**Haskoning Australia PTY Ltd.
Maritime & Aviation**

Subject: Stockton Boat Harbour Upgrading - Structural Adequacy of Heritage Seawall in North-Eastern Corner

DEMOLITION PLAN

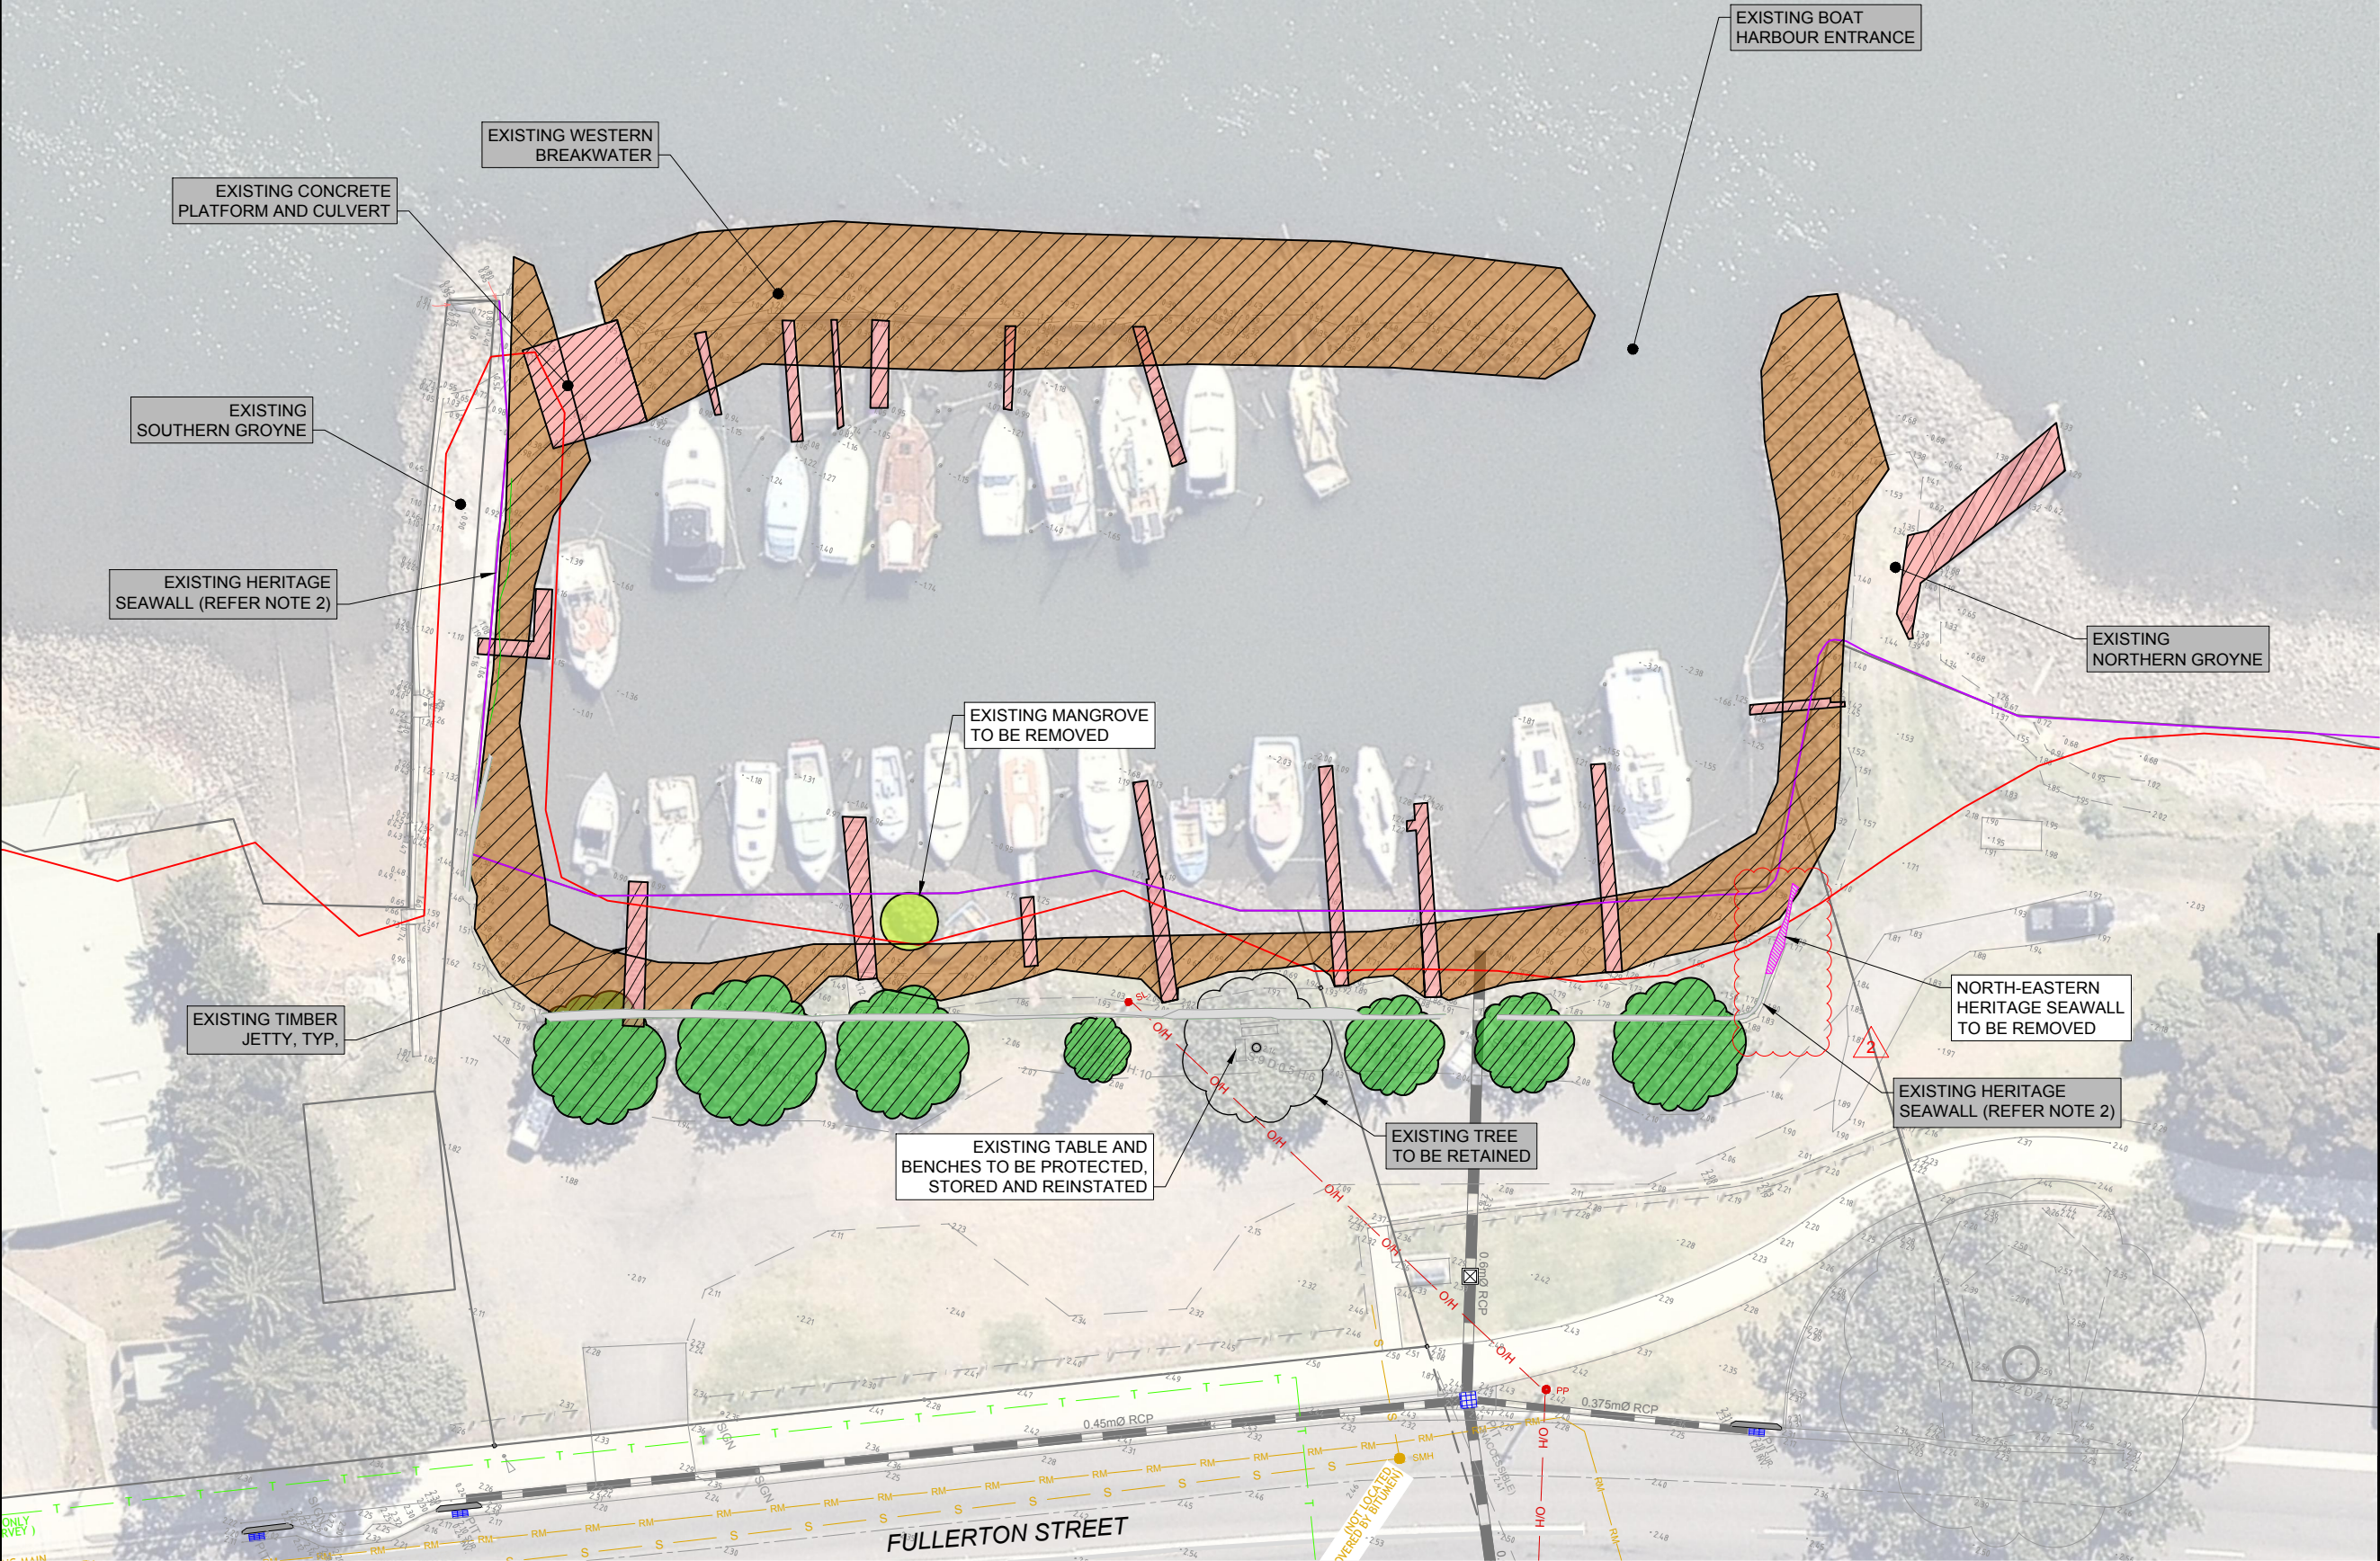
The remaining 4.4m of the westward length of the seawall from the NE corner (from CH1.2 to CH5.6) would be retained and a seawall face height of 0.5-0.6m would still be visible above the proposed rock revetment (approximately 3-4 block courses). The visibility of the seawall corner is considered to be beneficial as the historical perimeter of the old Boat Harbour is able to be determined from the remnant structure and potentially supplemented with interpretive signage on the foreshore.

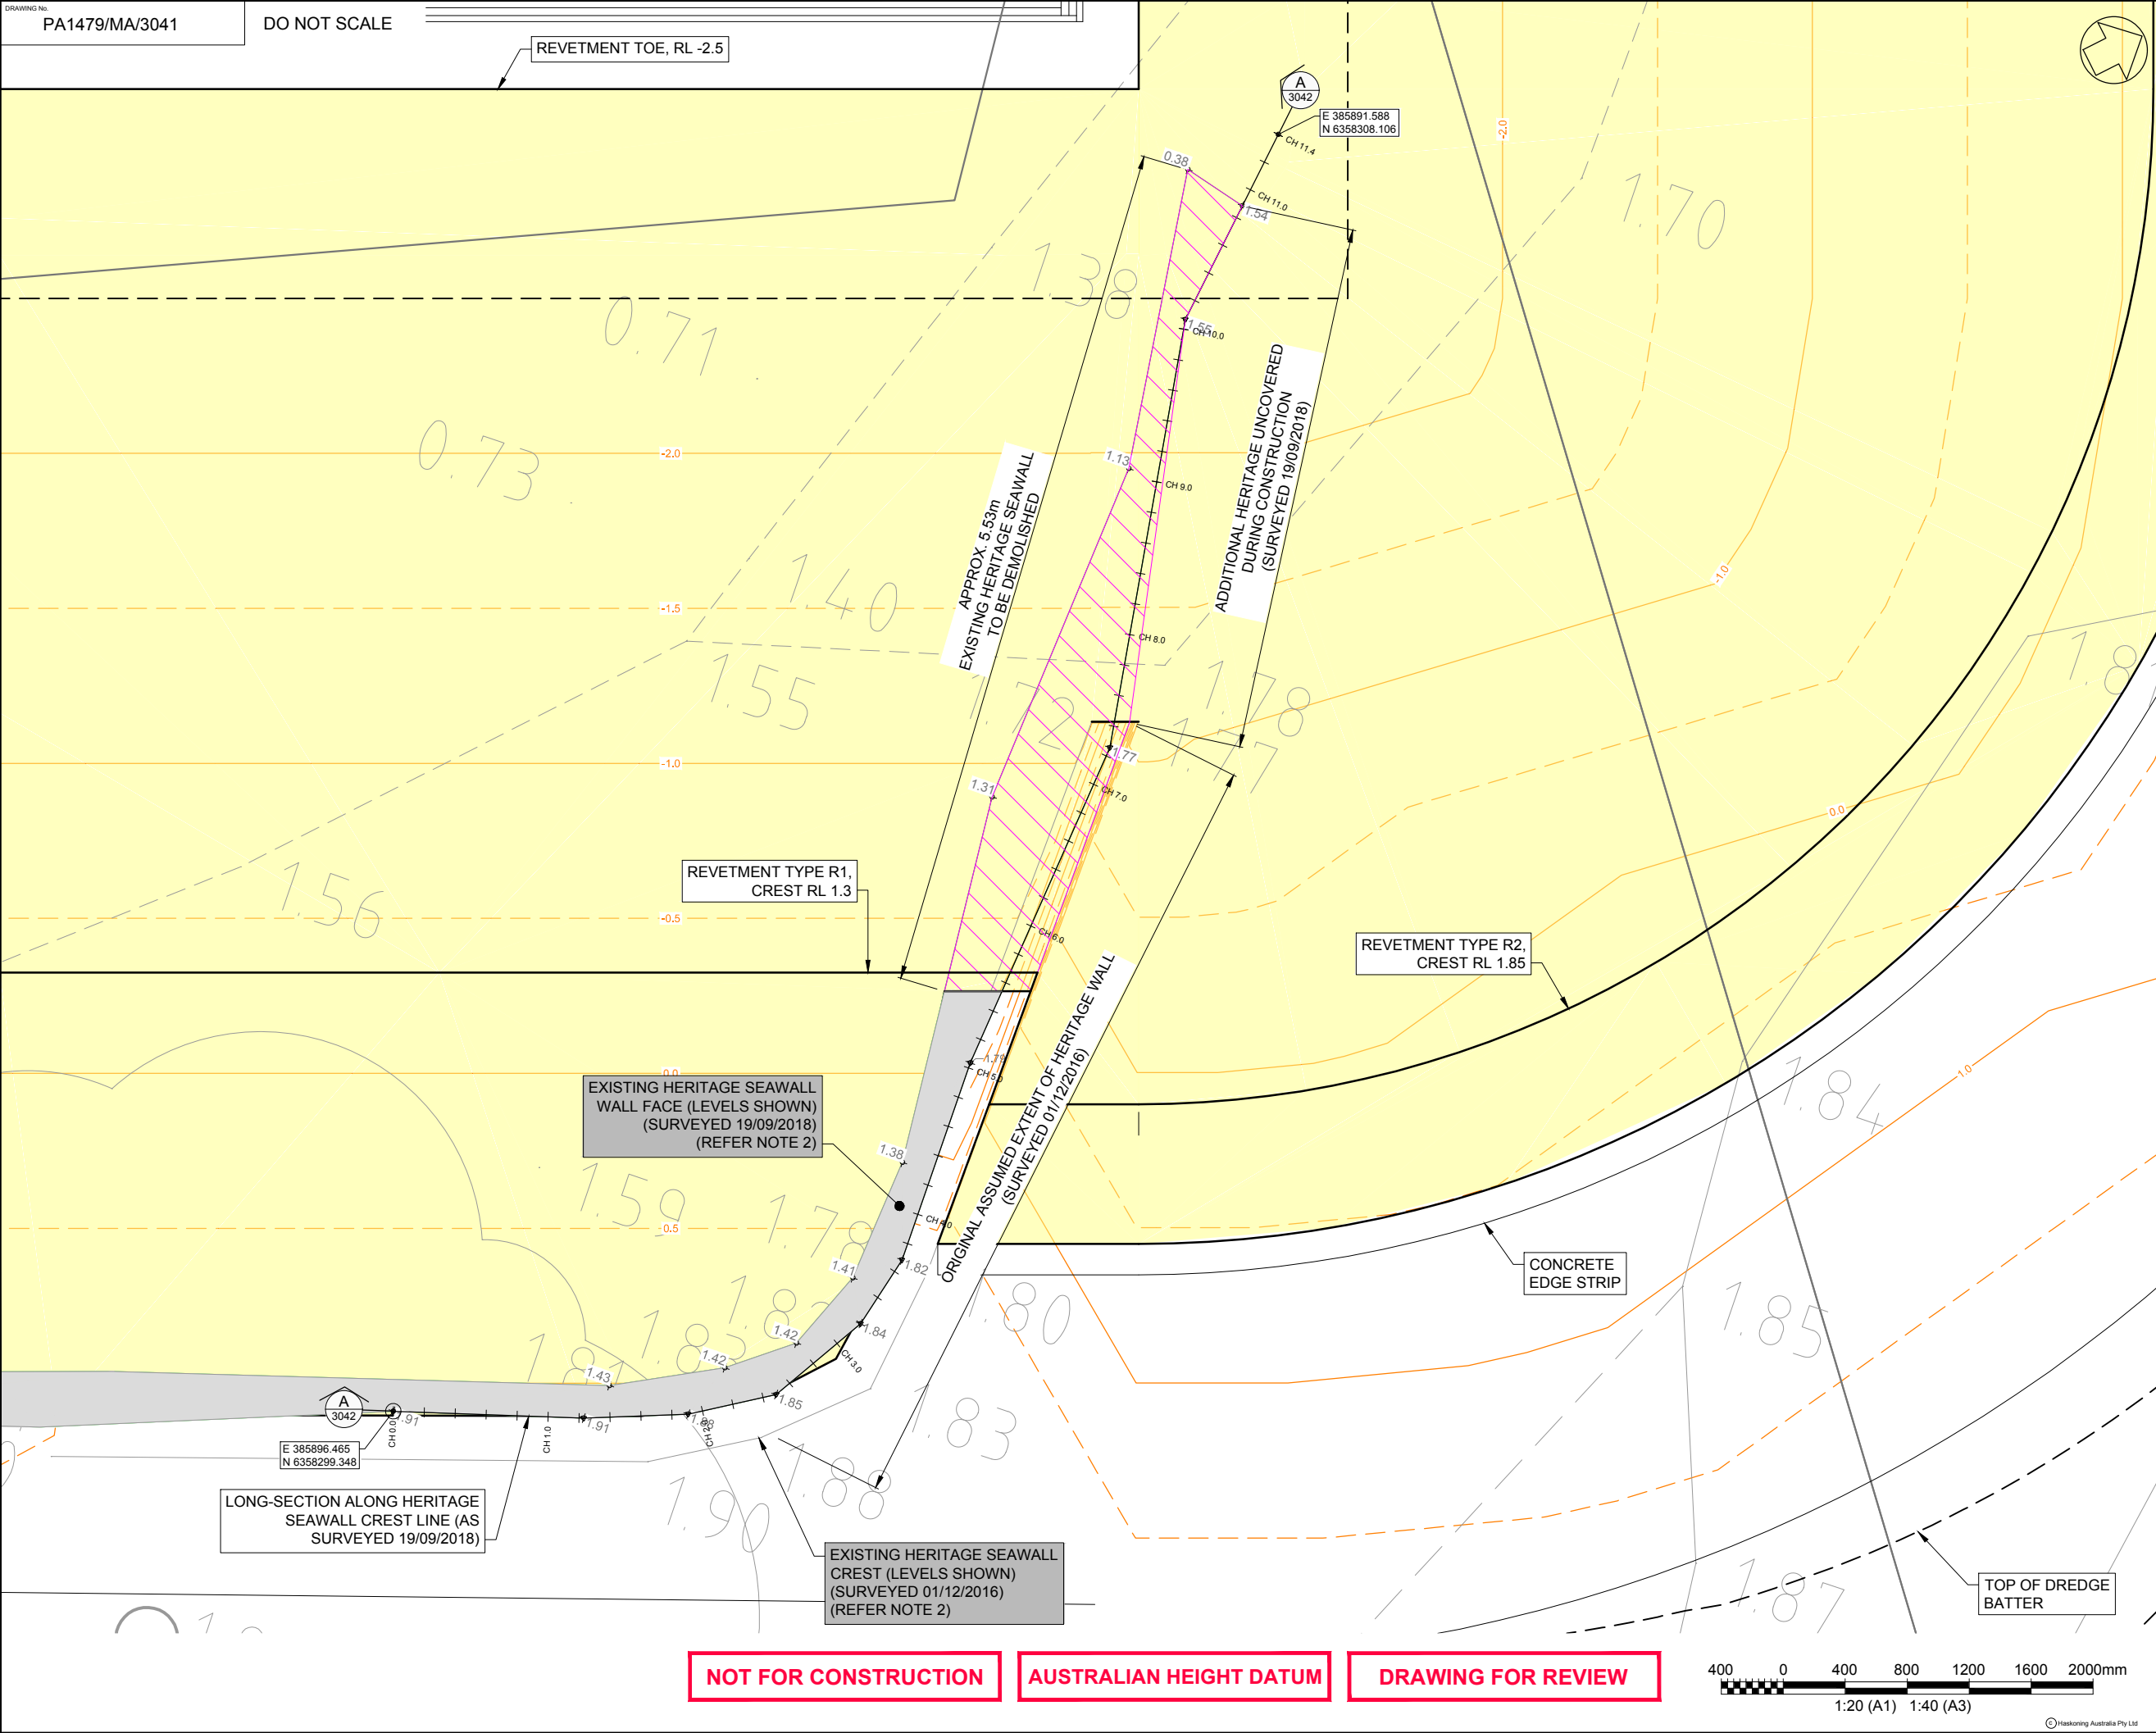
A plan and long section along the seaward face of the heritage seawall has been prepared (refer **Attachment A**) to show the elevations of the seawall crest and toe in comparison to the proposed rock revetment structure (armour and underlayer). The toe of the seawall would need to be protected by an armour and underlayer at least 2 rocks thick to prevent undermining of the material beneath the seawall toe by waves and currents within the Boat Harbour. The position at which this is achieved corresponds to CH5.6 on the long section. This requires a seawall length of approximately 5.3m to be demolished from CH5.6 to CH10.9. This section of the seawall is unable to be supported or protected by the adjacent proposed rock revetment and is unable to be underpinned with a foundation as the revetment profile extends several metres below the toe of the seawall.

It is noted that a section of retained seawall between CH3.6 and CH5.6 could potentially be undermined by the proposed temporary excavation profile, which is nominally shown at a 1V:2H slope. This could be mitigated by local excavation of a steeper temporary batter slope of 1V:1.5H and/or with temporary shoring of the seawall prior to rock placement.

It is recommended that deteriorated sections of the retained seawall are remediated with appropriate grout and/or mortar repairs, particularly in sections that are proposed to be exposed above the revetment surface.
